RE: Response to Submission for Unanderra Liquid Waste Treatment Facility SSD-8304

The following outlines additional information and clarification to address the New South Wales (NSW) Department of Planning, Industry and Environment (DPIE) and NSW Environment Protection Authority (EPA) requests for further information relating to the *Air Quality Impact and Greenhouse Gas Assessment Hydromet Liquid Waste Treatment Plant* (the AQIA) (**Todoroski Air Sciences, 2021a**) and the *Noise Impact Assessment Hydromet Liquid Waste Treatment Plant* (the NIA) (**Todoroski Air Sciences, 2021b**).

**Figure 1 – Schematic Arrangement of Neutralisation Reactor Scrubber Circuits**

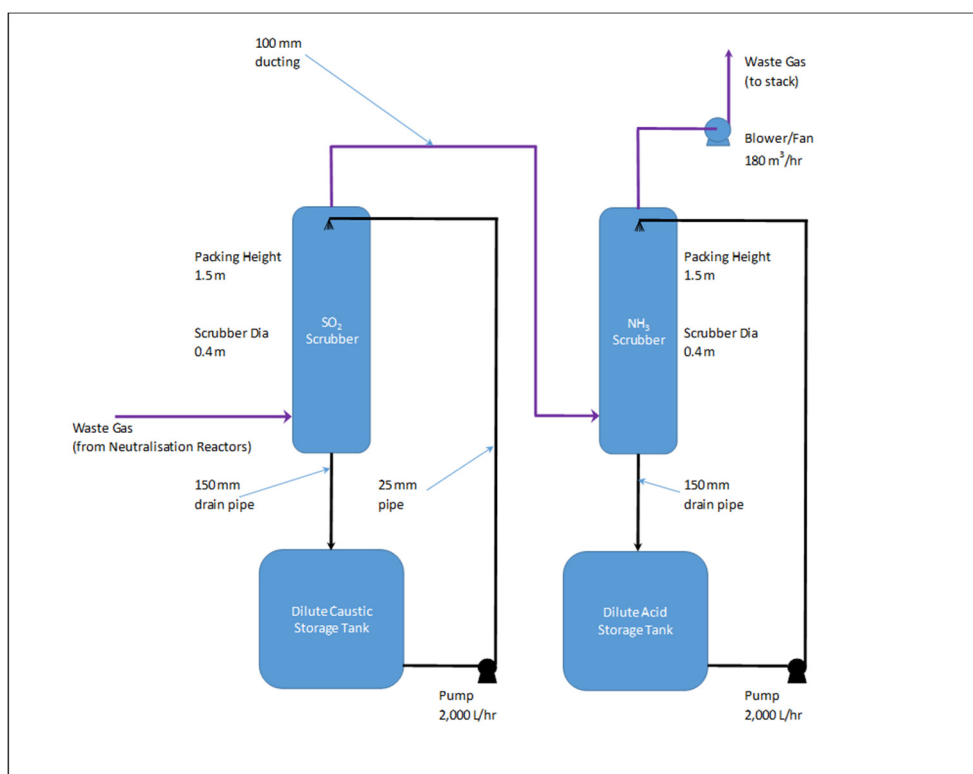
- Confirm the air quality impact assessment (AQIA) includes the proposed scrubber for Building E and provide details of this scrubber.

The operation of a scrubber for Building E has been included and is assessed in the AQIA. The scrubber is designed to treat air emissions generated because of an unusual event during the neutralisation process that would not normally occur during typical operations.

The scrubber in Building E comprises a SO_x scrubber followed by NH₃ scrubber connected in-series and is a contingency in case of a process deviation that could potentially generate waste gases from the

LWTP neutralisation reactors. The scrubber columns will be designed to be approximately 400 millimetres (mm) in diameter and contain 1.5 metres (m) of packing. The SO_x scrubber will be irrigated with around 2000 litres per hour (L/hr) of dilute caustic scrubbing solution and the NH₃ scrubber irrigated with a dilute acid solution at a similar rate.

The scrubber is designed with an exhaust exit velocity of 15 metres per second (m/s) and a maximum emission concentration of 100 parts per million (ppm) of SO_x and 15ppm of NH₃.
